**Committee Report in respect of the previous application for mixed use development on
the Application Site, submitted in March 2008**

2008/0561

Hartwood Estates

Erection of a mixed use development (Use class A1, A3, A5 and B1)

PLANNING LAYOUT

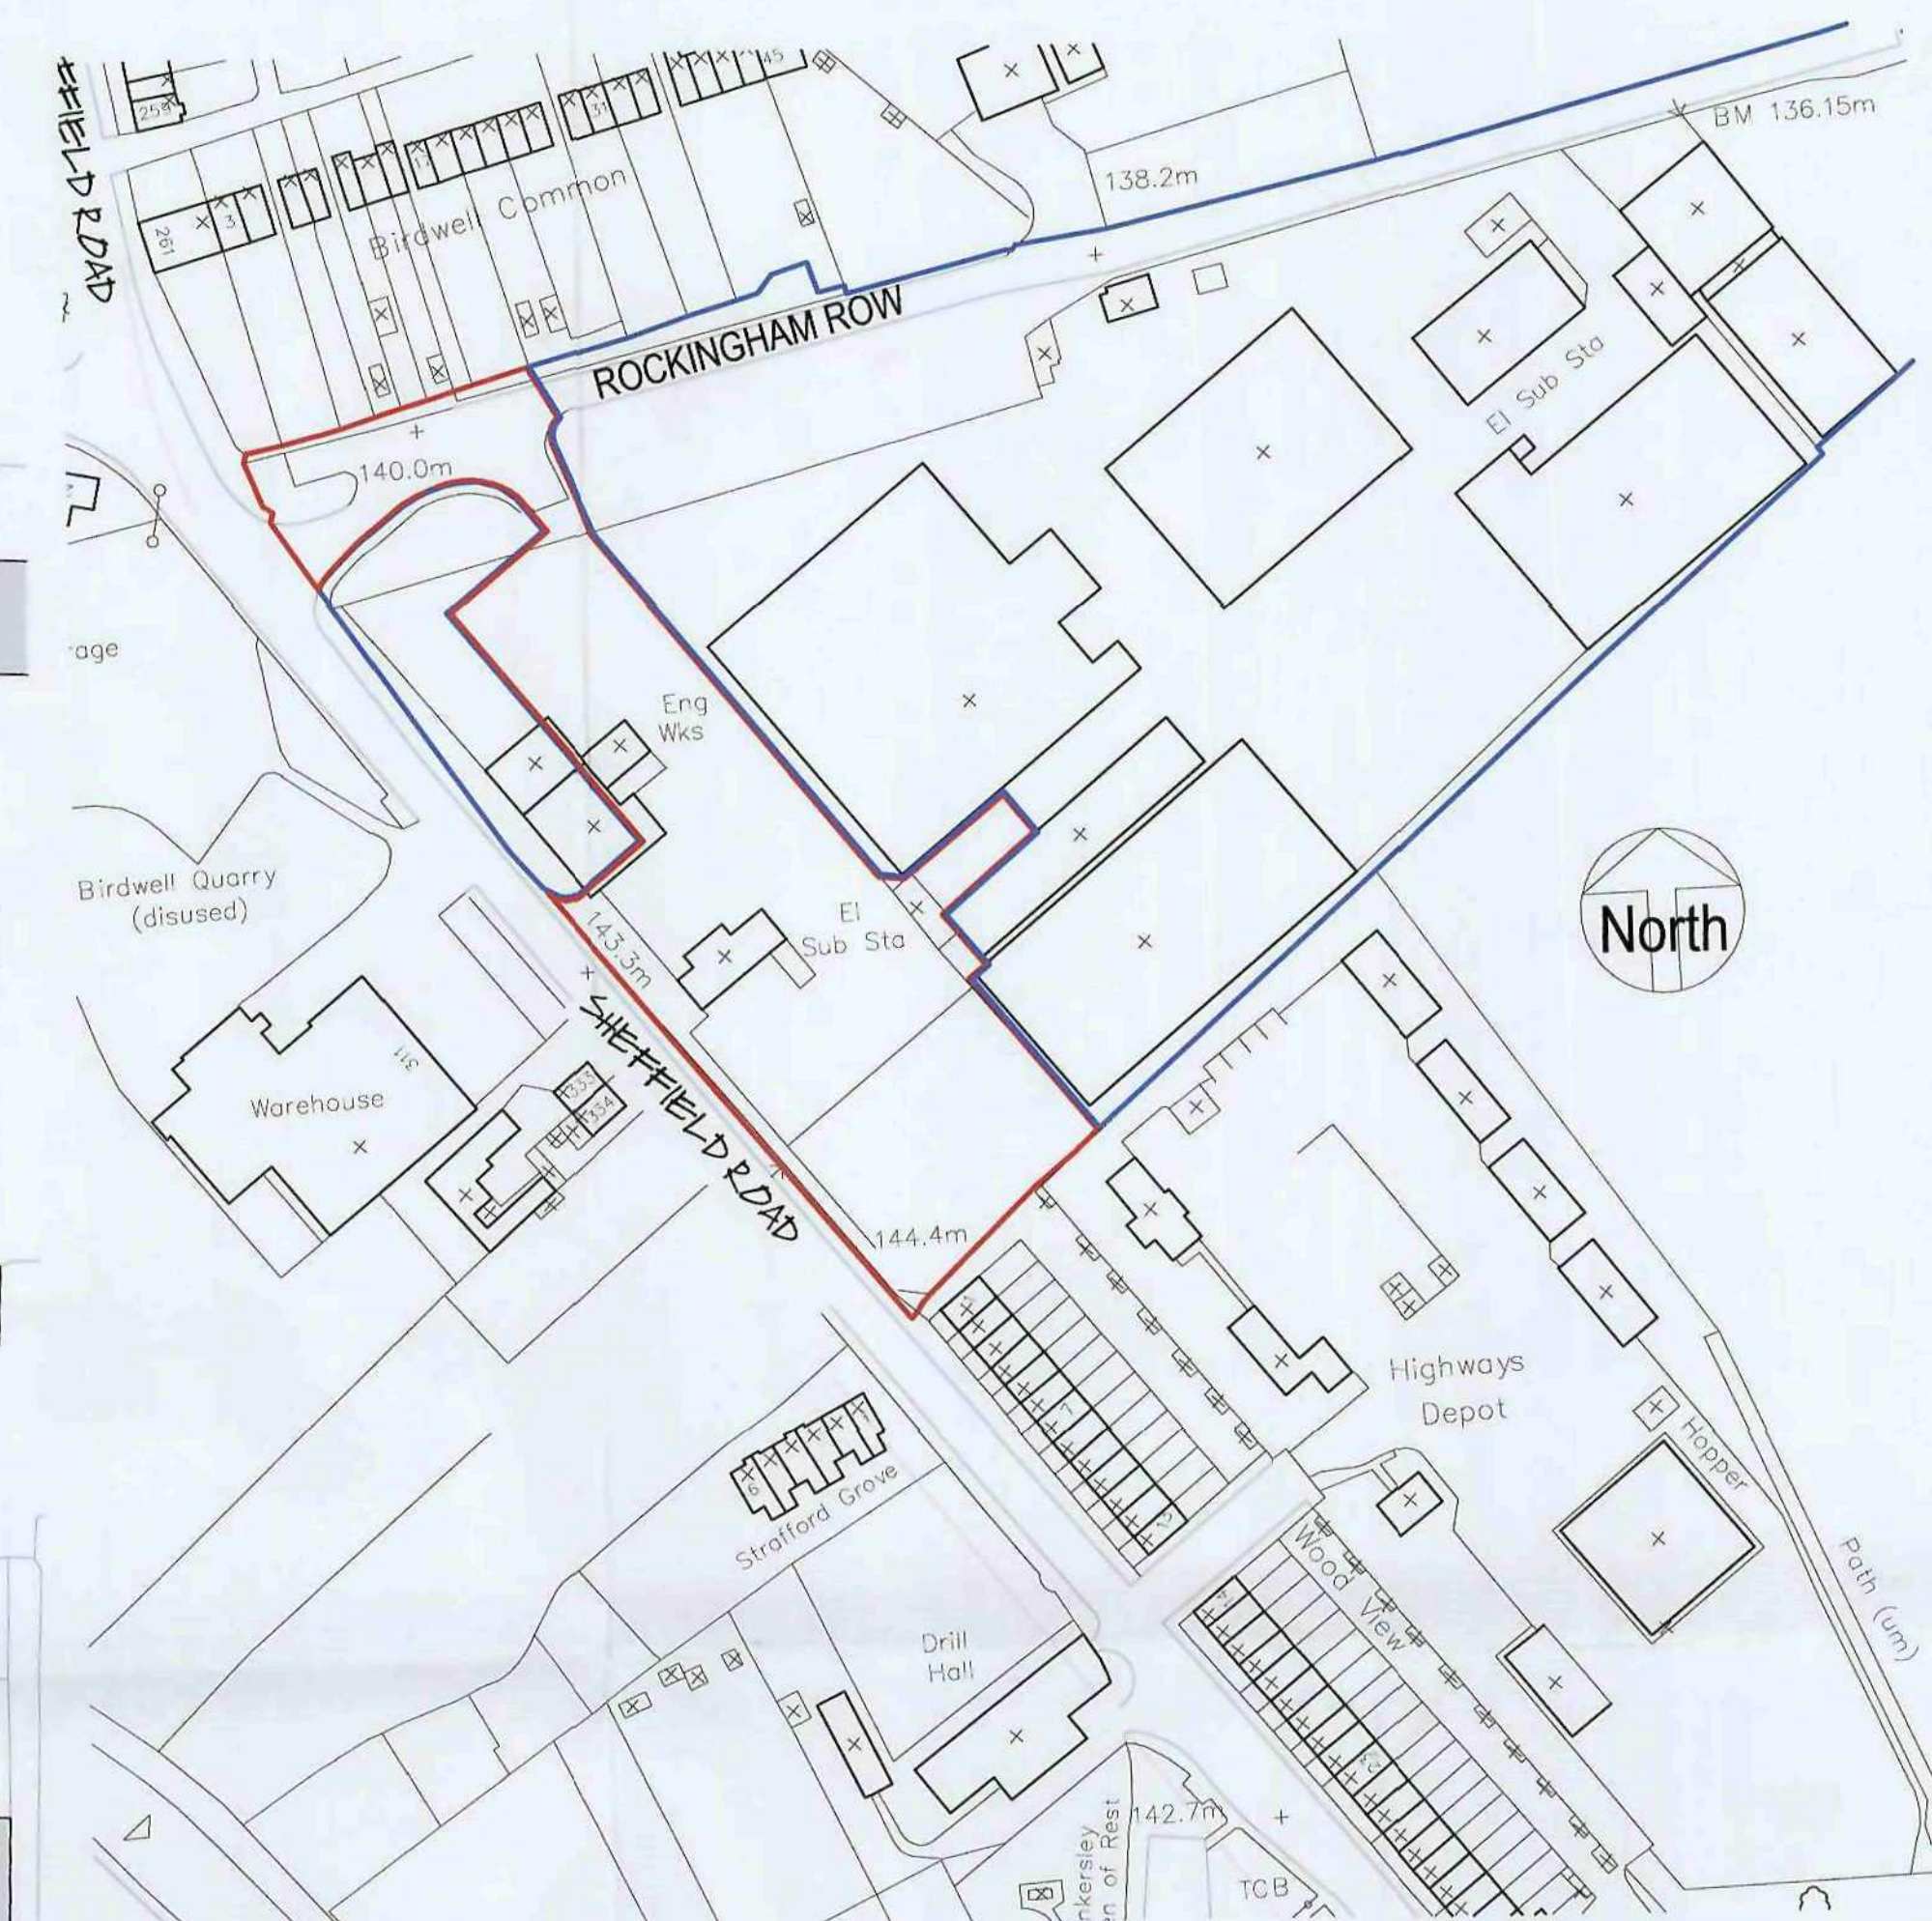
In this instance, whilst the design of the buildings is considered to be 'safe' and 'traditional', they would be dominated by roofspace and set back from the road by a substantial car parking area. Although it is accepted that having car parking areas visible is necessary in order to attract customers into the site, the site would contribute little to the street scene. The car park would be surfaced in tarmac and incorporate only small amounts of planting which would result in an almost sea of black within the confines site, which is an undesirable design feature, particularly at this prominent location.

Although in general Highways raise no specific objections to the scheme, they consider that to accommodate a mixed use development on the site with a principle customer access off Sheffield Road, highways improvement works and changes to the internal car parking layout would be required.

In the opinion of the Local Planning Authority the design of the scheme on this prominent site is considered to be bland, uninspiring and over dominated by car parking and, as a consequence, fails to take the opportunity available with this largely vacant site for improving the character and the quality of the area. The scheme is therefore considered to be contrary to Barnsley Unitary Development Plan Policy BE6.
